## Consultation Response from: KC Environmental Health (Pollution & Noise Control)

**2025/92161 - Land adj 17 Whitehall Road West, Birkenshaw, BD11 2LS**

**Discharge of details reserved by conditions 4-8 (intrusive investigations), 11 (Remediation Strategy and Verification Report ), 12 (CEMP), 13 (noise), 14 (Arboricultural Method Statement), 15 (CMP), 16 (highway), 17 (visibility), 18 (Safety Audit), 19 (estate streets), 20 (waste collection), 21 (surface water attenuation), 24 (bin storage), 25 (bicycle storage), 26 (drainage), 28 (drainage), 29 (CEMP: Biodiversity),-30 (landscape), 34 (solar panel array), 35 (materials), 38 (boundary treatments) on previous permission 2024/92281 for erection of 23 dwellings**

**Responding Date: 27th August 2025      Responding Officer: SR, MN**

Appendix 5 Façade Mitigation Measures

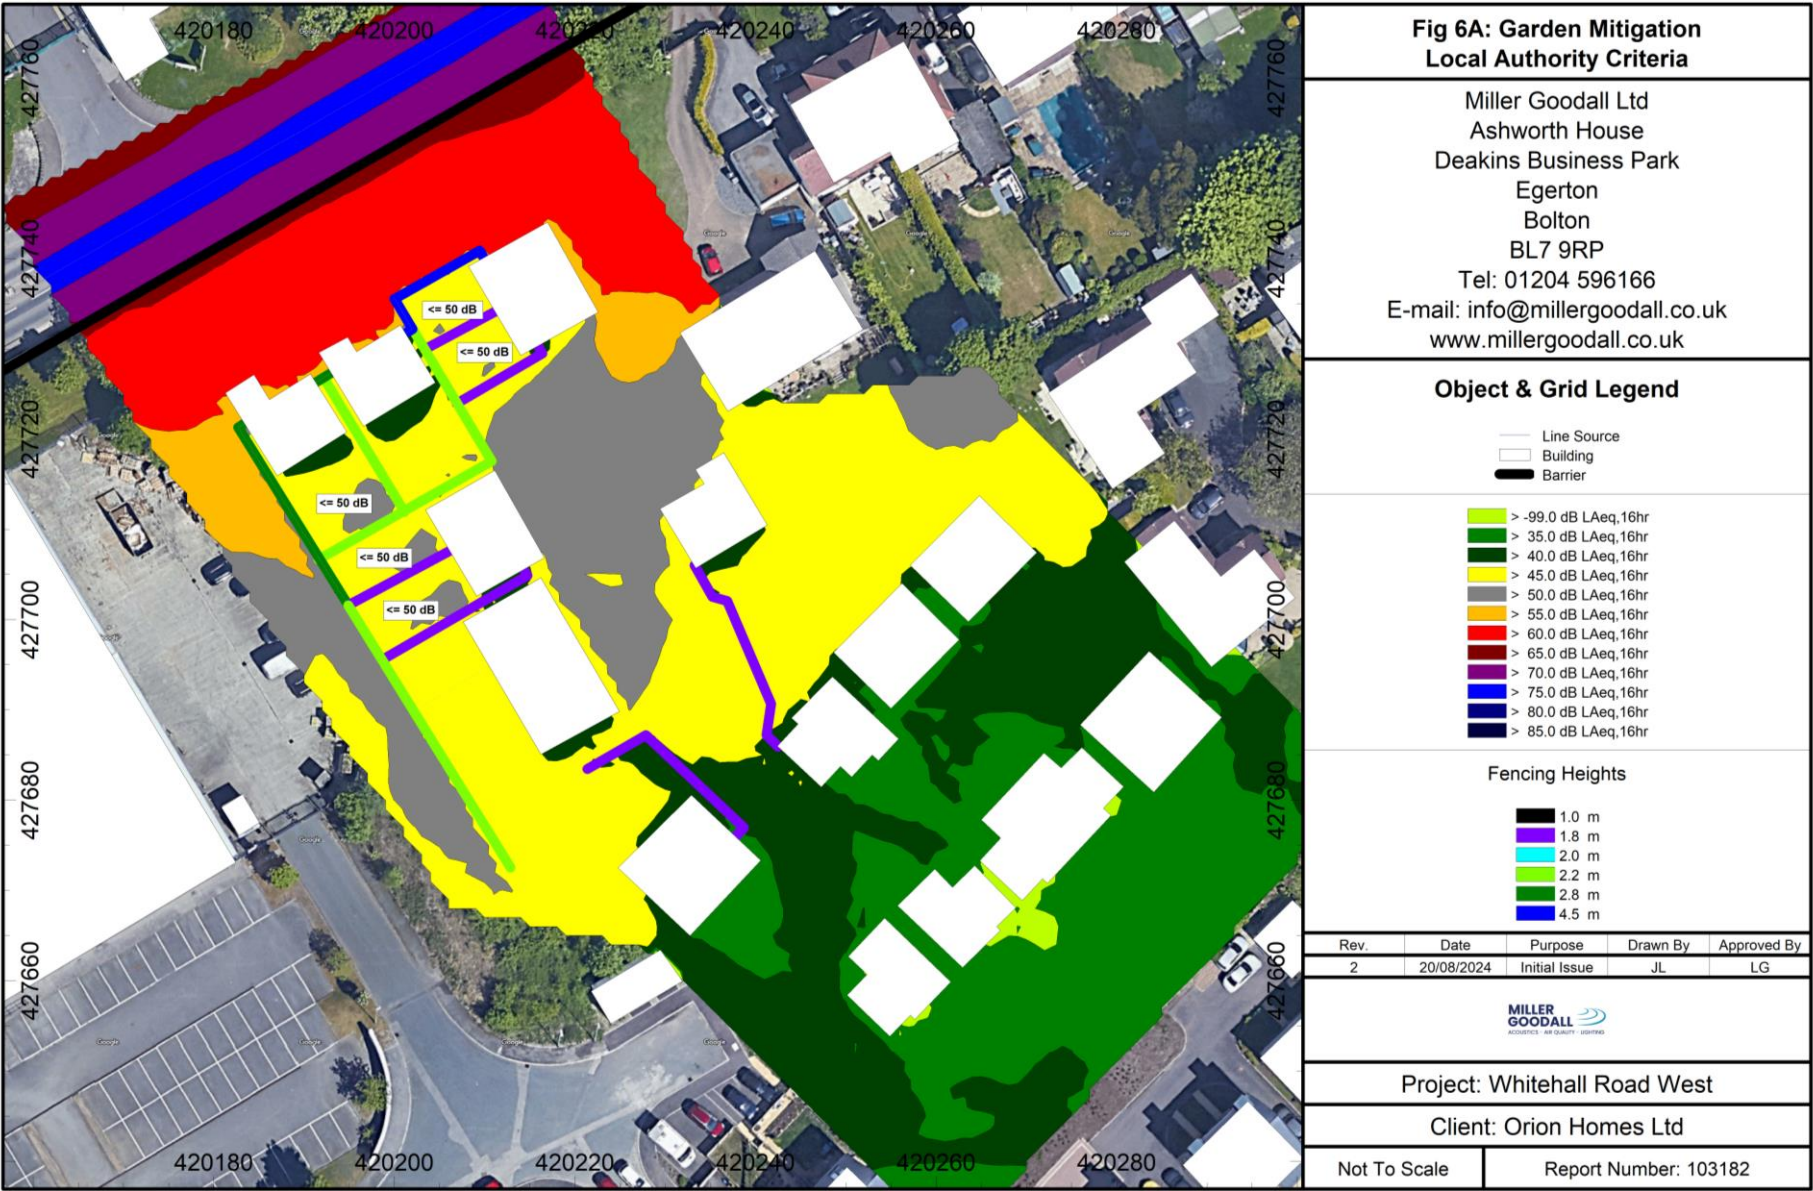
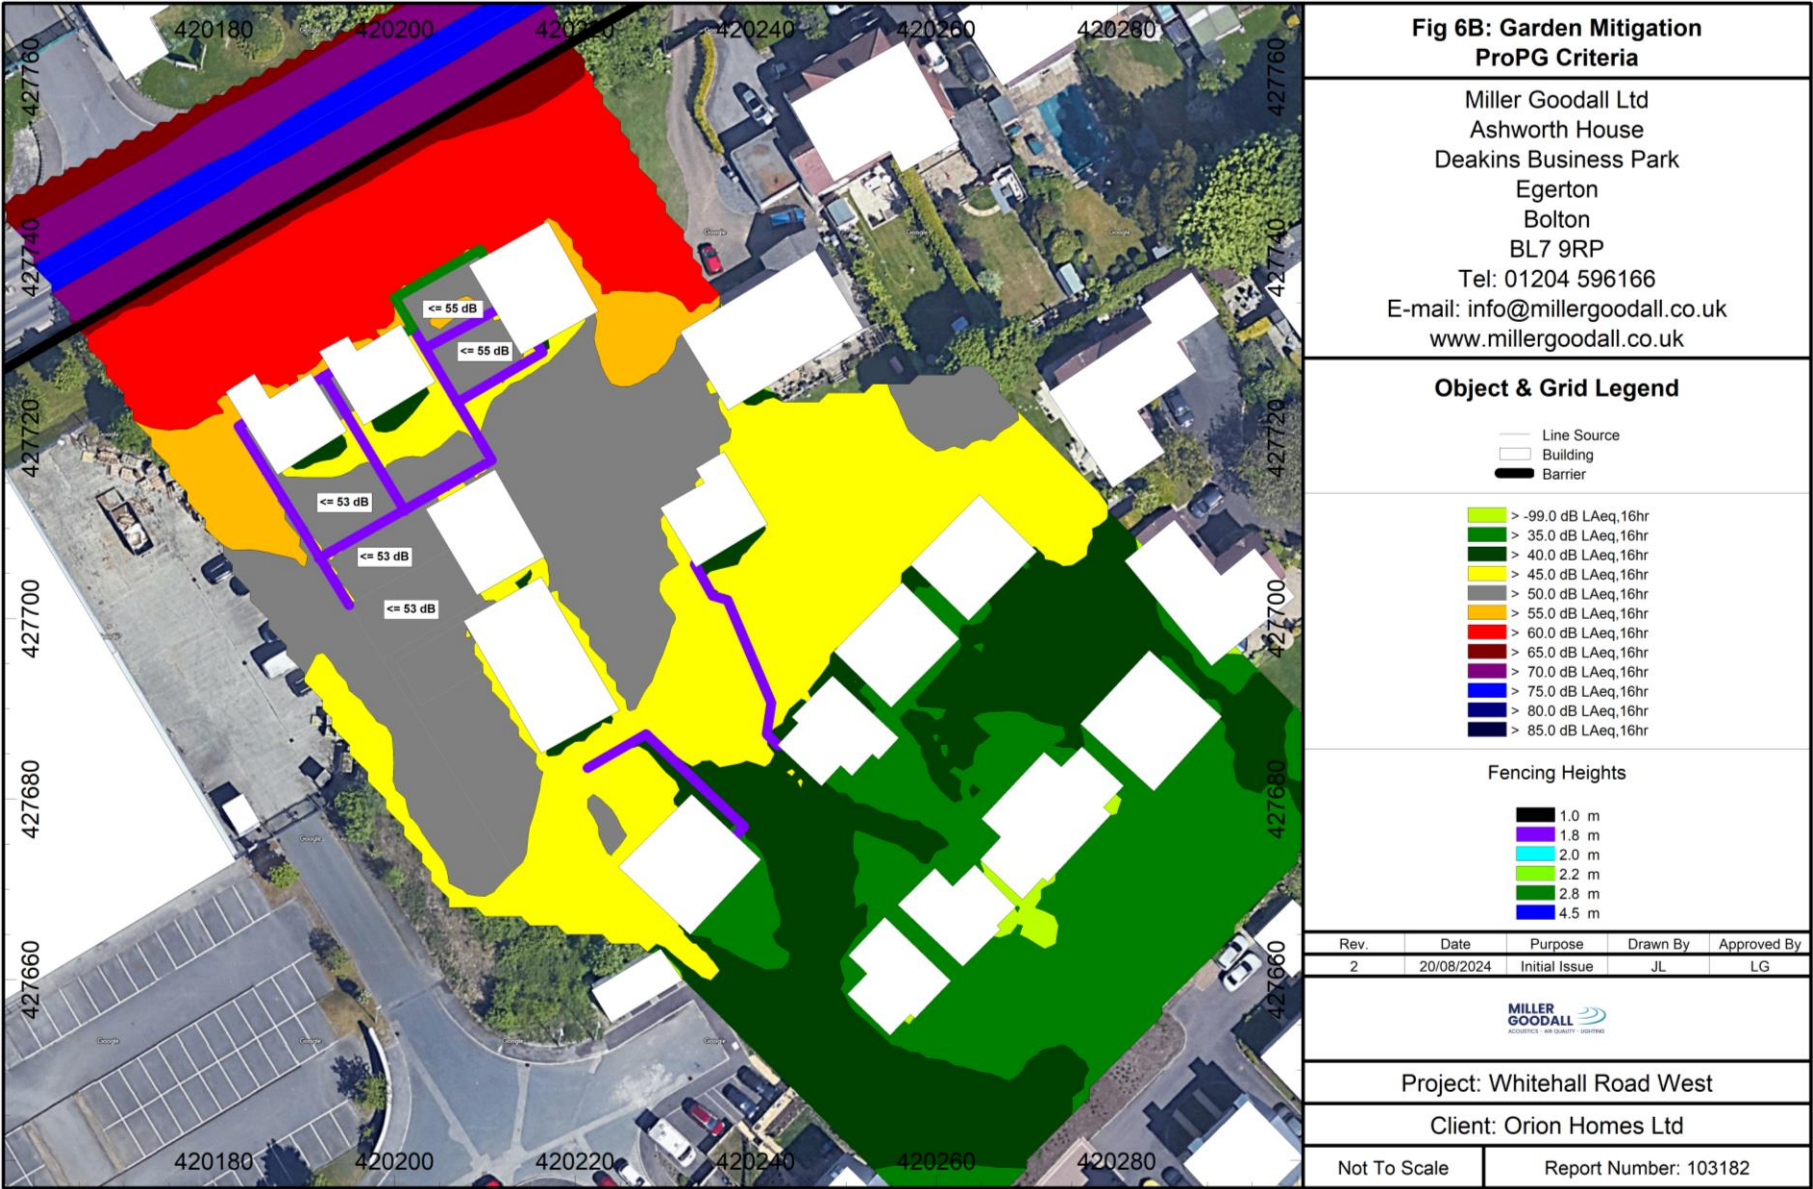
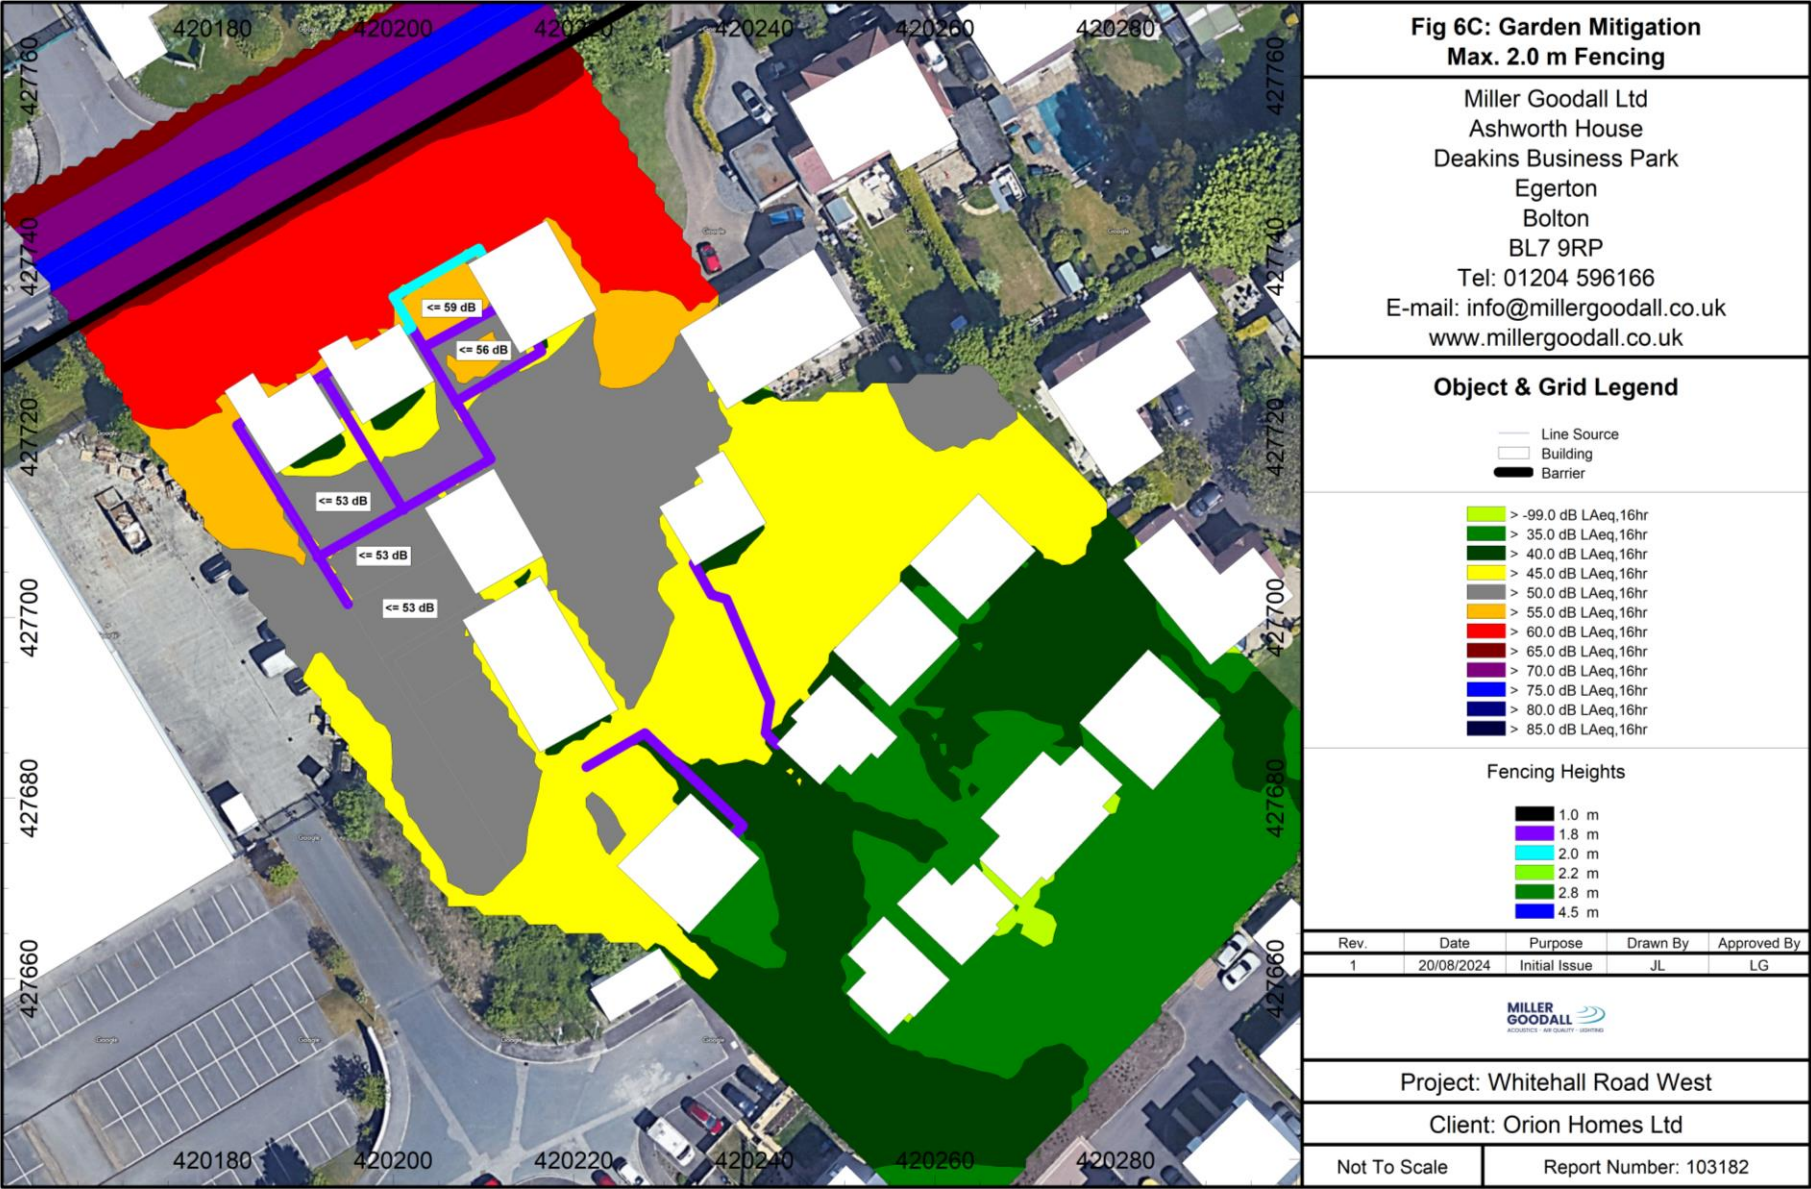
Noise modelling has been conducted and in order to meet with the internal requirements of BS8233, glazing and ventilation is specified according to the façade (1 - ground floor and 2 – first floor). It would be appropriate to use façade 1 throughout the site but not façade 2 throughout and that all façades marked with green may utilise openable windows. This is reflected in the colour coded plan within Appendix 5.
